Project Special Provisions
(Version 06.5)
Signals and Intelligent Transportation Systems

Signals & Intelligent Transportation Systems

The 2006 Standard Specifications are revised as follows:

INDUCTIVE DETECTION LOOPS
ENGLISH DETAIL DRAWING FOR

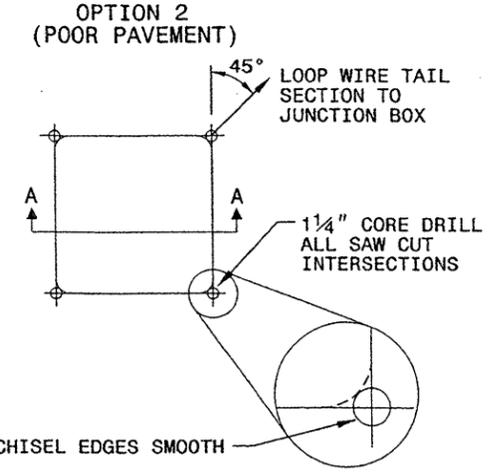
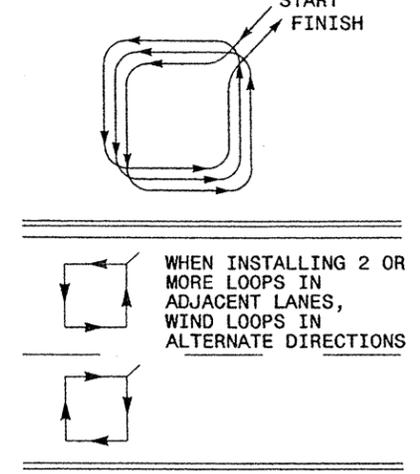
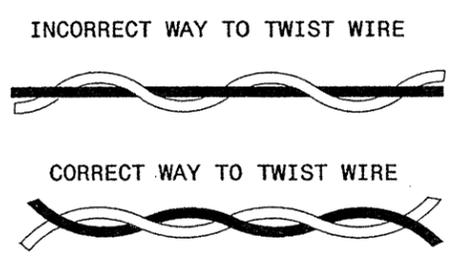
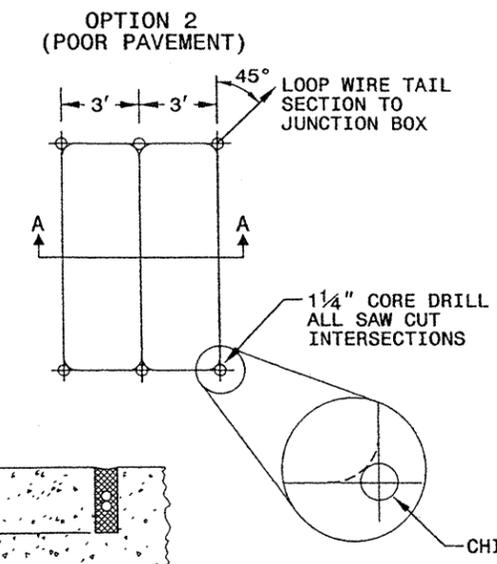
“Twist loop conductor pairs a minimum of 5 turns per foot from where conductors leave saw slot to junction box.

ENGLISH DETAIL DRAWING FOR
INDUCTION DETECTION LOOPS
SPlicing FOR LEAD-IN CABLE AND LOOP WIRE

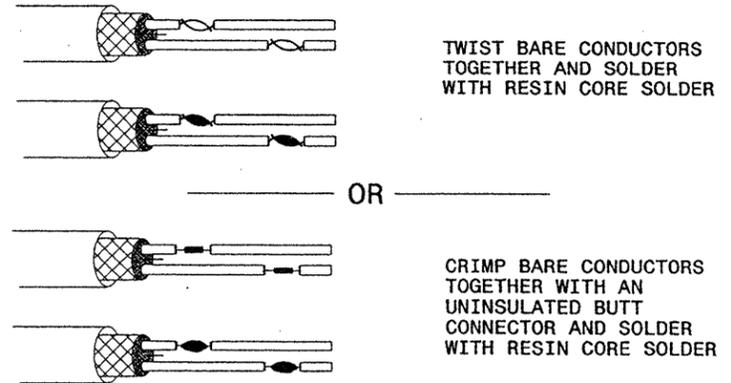
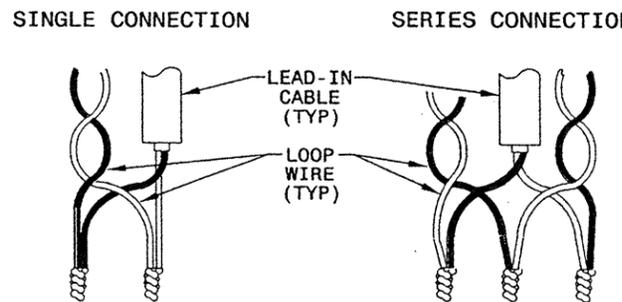
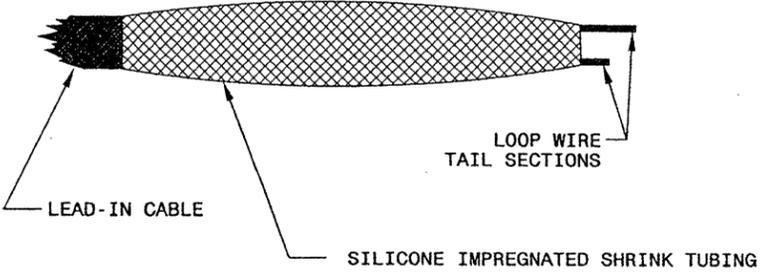
Furnish lead-in cable with two conductors of number 14 AWG fabricated from stranded tinned copper that complies with IMSA Specification 50-2 except as follows:

Ensure conductor is twisted with a maximum lay of 2.0 inches, resulting in a minimum of 6 turns per foot.

Provide a ripcord to allow cable jacket to be opened without using a cutter.

Provide length markings in a contrasting color showing sequential feet and within one percent of actual cable length. Ensure character height of the markings is approximately 0.10 inch.
